11<sup>th</sup> November 2024

**Coalcliff Eco-Tourist Facilities (Pre-Development Application PDA-75447712)**

This letter has been prepared by Ethos Urban on behalf of Urban Property Group to provide the additional information as requested by the Department of Planning, Housing and Infrastructure (DPHI) under Pre-Development Application PDA-69123209, to enable the request for Secretary’s Environment Assessment Requirements (SEARs) relating to the provision of Eco-Tourist Facilities, Environmental Facilities and Environmental Protection Works at Lot 100 DP 715376, Lawrence Hargrave Drive, Coalcliff.

Figure 3 Eastern portion indicative site plan (eco-tourism and environmental facilities)

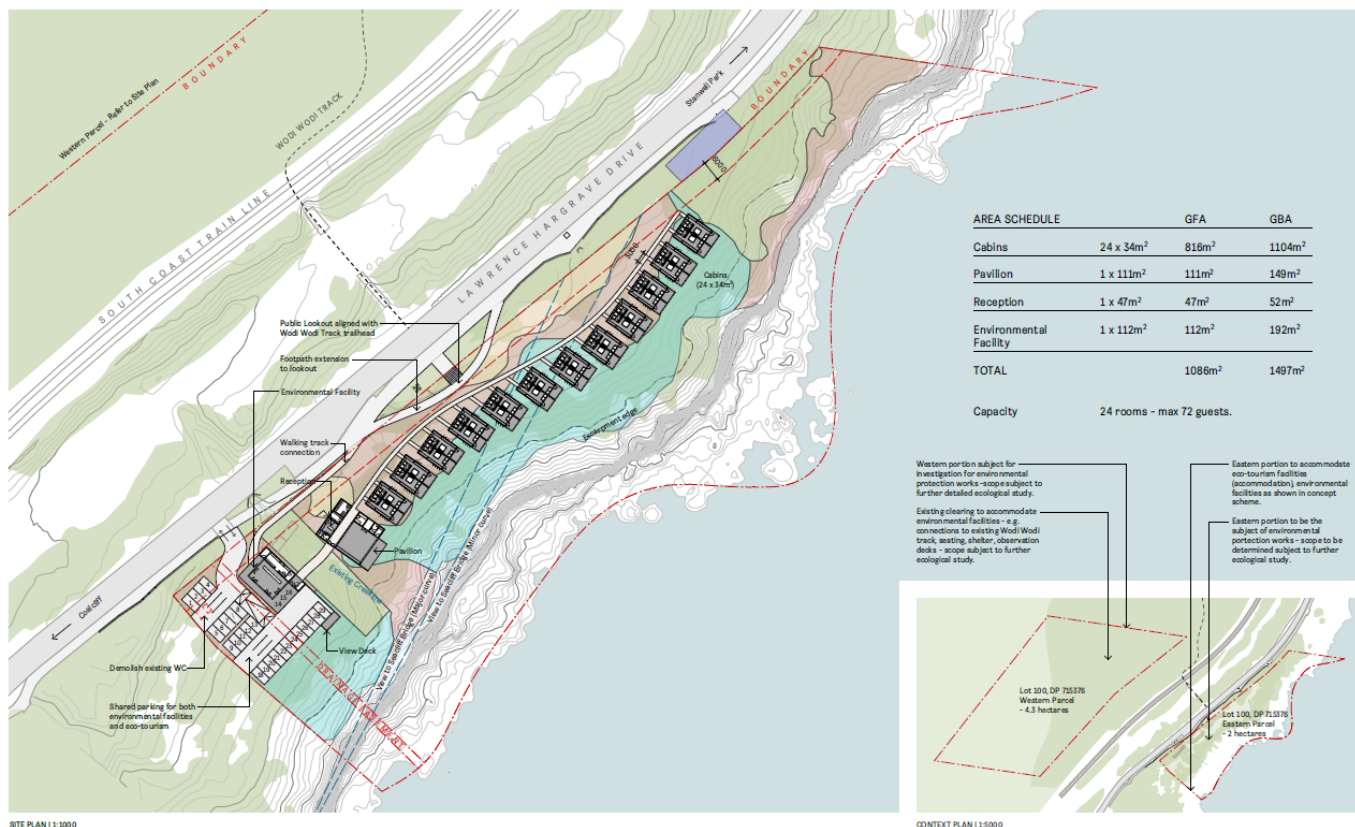
<p>The proposed site configuration is spread out and, in turn, may increase the size of any required Asset Protection Zones and clearing: Section 3.4 Analysis of Alternatives in the scoping report does not adequately address feasible alternatives, or impacts associated with them.</p>	<p>The Asset Protection Zones of the site have been identified as part of the design development process as identified in <b>Appendix B</b>. An assessment against the bushfire hazard will be further developed during the preparation of the EIS.</p> <p>See <b>Section 3.4</b> in the Scoping Report for further information.</p>
